From: East Preston Parish Council (SC) [REDACTED]
Sent: 21 January 2019 11:39
To: Juan Baeza
Subject: EPPC response to EP/160/18/PL - OBJECTION
Importance: High

From: East Preston Parish Council (SC) [REDACTED]
Sent: 29 December 2018 09:25
To: planning.responses@arun.gov.uk
Cc: Juan Baeza (Juan.Baeza@arun.gov.uk)
Subject: EPPC response to EP/160/18/PL - OBJECTION

Proposed Roof Tile – Marley Modern Tile, colour smooth grey.

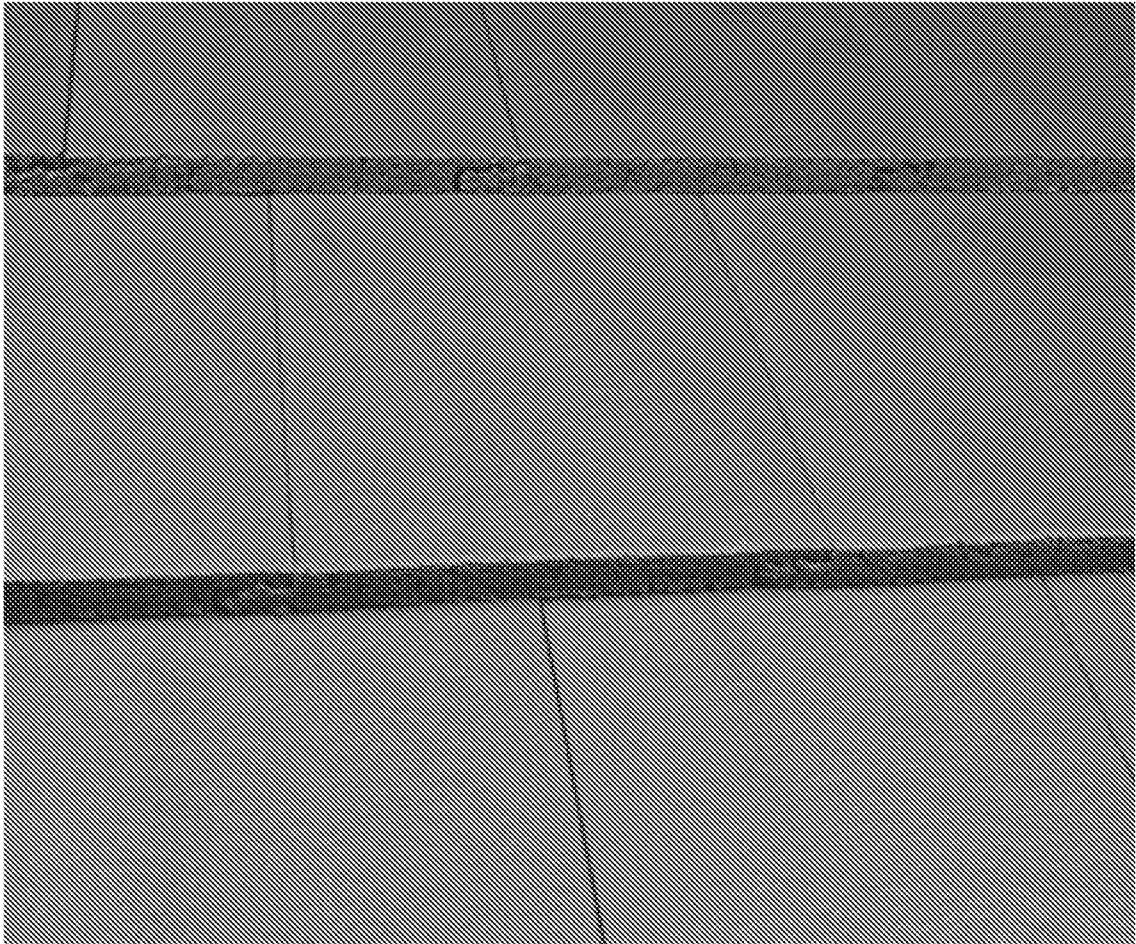
The committee agreed to object to this Application as it agreed with the view of the East Preston & Kingston Preservation Society that the colour chosen for the roof is not in keeping with other properties in Beechlands Close. For this reason, this council asks Arun District Council to consider refusing Planning Permission for this Application.
